Subject: RE: Planning Consultation on: LU/116/21/PL

Response to Planning Application

Application ref: LU/116/21/PL - Revision

Description: Erection of 112 No. residential units with access from Fitzalan Road, open space, hard and soft landscaping works, internal roads/footways, car and cycle parking, substation, bin store and associated engineering and infrastructure works. This site is in CIL Zone 4 (Zero Rated).

For Softworks key refer to
LTH-NTA-XX-00-DR-L-0505/0506

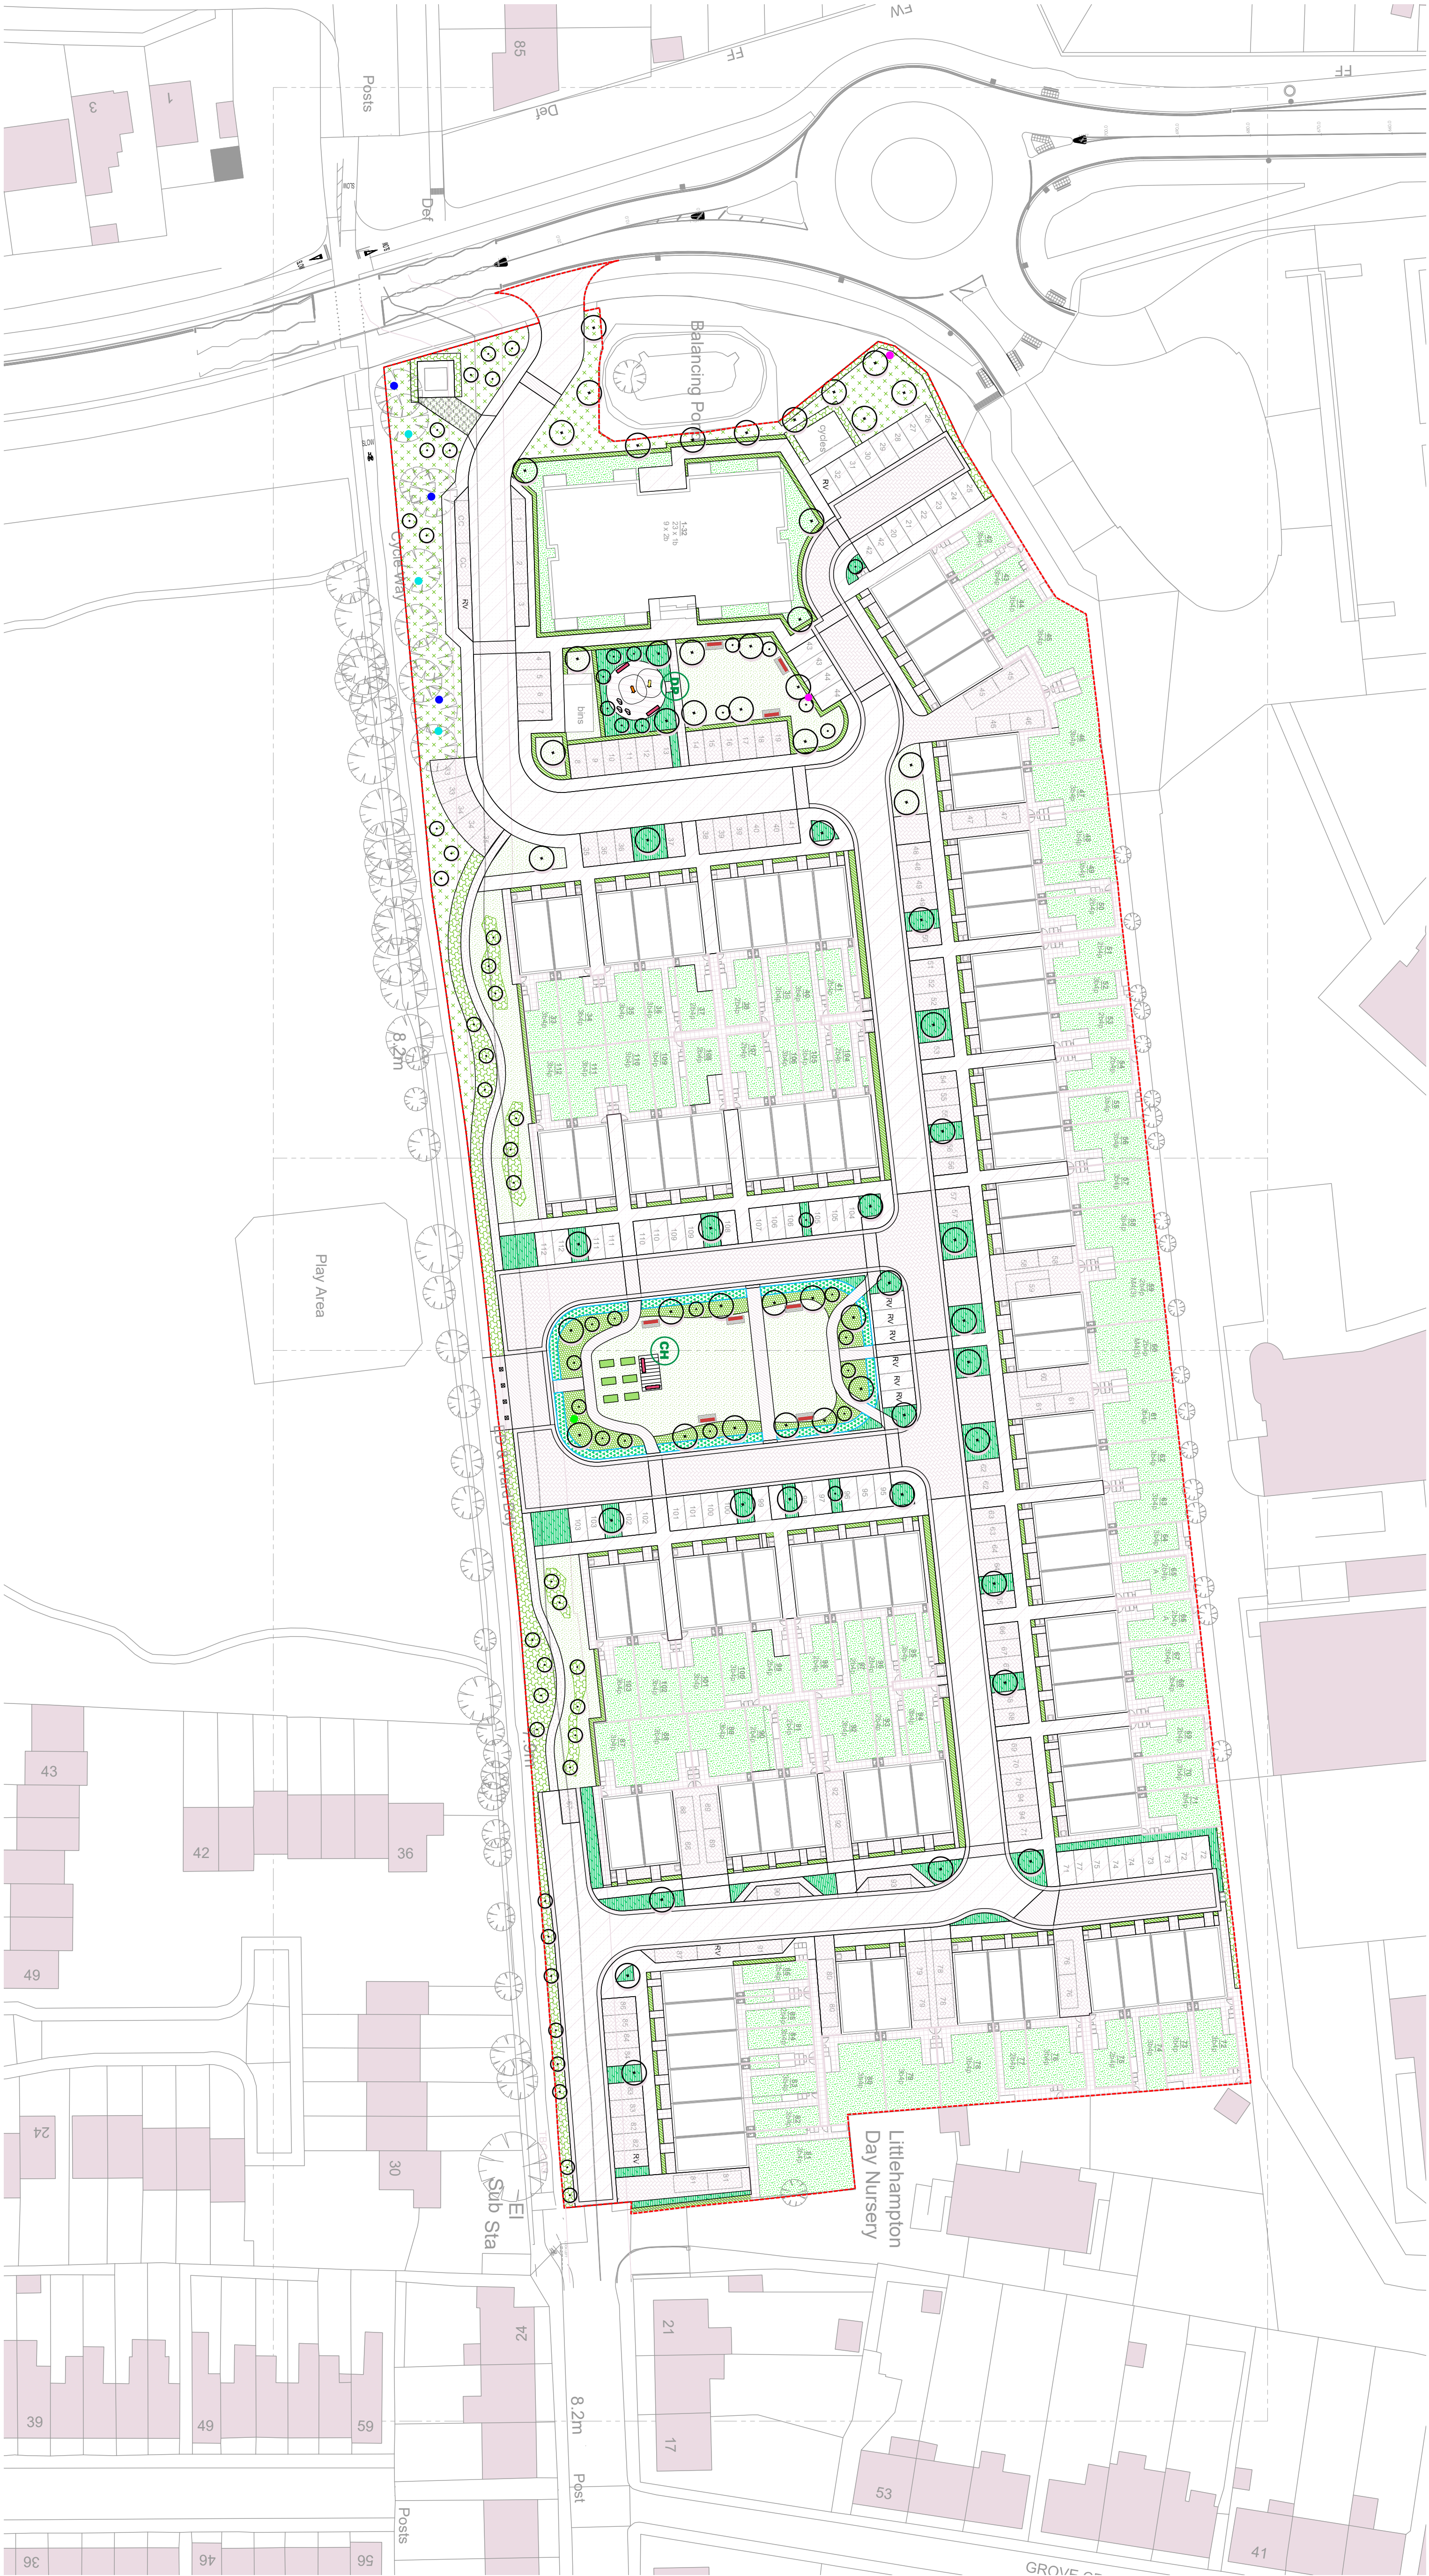
The detail under LU/55/15/OUT (68 dwellings) included a Public open space area centrally located within the development. The proposals under this REVISED application LU/116/21/PL now revised under substitute drawings Landscape Masterplan LTH-NTA-XX-00-DR-L-0501 Rev P04 Landscape GA softworks Sheets 1 of 2 LTH-NTA-XX-00-DR-L-0504 Rev P04 and Landscape GA softworks Sheets 2 of 2 LTH-NTA-XX-00-DR-L-0505 Rev P04 show a central POS area which is now allocated as POS with the children's play omitted in favour of 106 contribution which would be preferable. In addition also have been indicated within the 106 agreement offsite financial contributions for playing pitches/3G pools/ halls and ancillary facilities as outlined in ADC SPD Open Space, Playing Pitches, Indoor and Built Sports Facilities January 2020.

It had previously been recommended for play that a preference for offsite provision with a financial contribution for offsite provision made. It would be advised that play would be better situated as an offsite contribution and as agreed in the previous 106 application rather than located on this site. The previously drafted 106 agreement recognised the requirement for children's play and 106 monies were agreed for offsite improvements to Rosemead Park play area immediately to the south which is a Parish owned facility.

SuDS provision appears to have been shown now to the rear of the apartment block area (removed from the apartment block frontage which is preferable) the full implication of SuDS including future management and maintenance must be considered, also the proximity to these residential dwellings. The recommendation that these are subject to RoSPA or similar organisation inspection should be noted. Detail to be provided as to whether these are likely to be wet or dry areas; this has implications where situated near to residents and play areas. Where they are to remain wet for long periods their safety must be assessed regarding the proximity to residential areas. Any such SUDS features should be designed as beneficial wildlife, amenity and landscape features and incorporated as part of an open space or landscaping scheme for the development.

Pedestrian and cycle routes within the development will need to provide purposeful links for connectivity beyond the development site. Pedestrian and cycle links to Fitzalan Road, Elm Grove Road and the POS to the south of the site need to be ensured.

Summary recommendation: Recommend landscape approval of the relocating of the children's play via Section 106 contributions into the adjacent Rosemead play area for improvement and therefore allowing the shown central POS area now available as suitable POS (considering also the adjacent greenspace) for the whole development. Landscape whole site scheme detail to be submitted and approved.

Recommend landscape approval of the relocating of the children's play via Section 106 contributions into the adjacent Rosemead play area for improvement and therefore allowing the shown central POS area now available as suitable POS (considering also the adjacent greenspace) for the whole development.
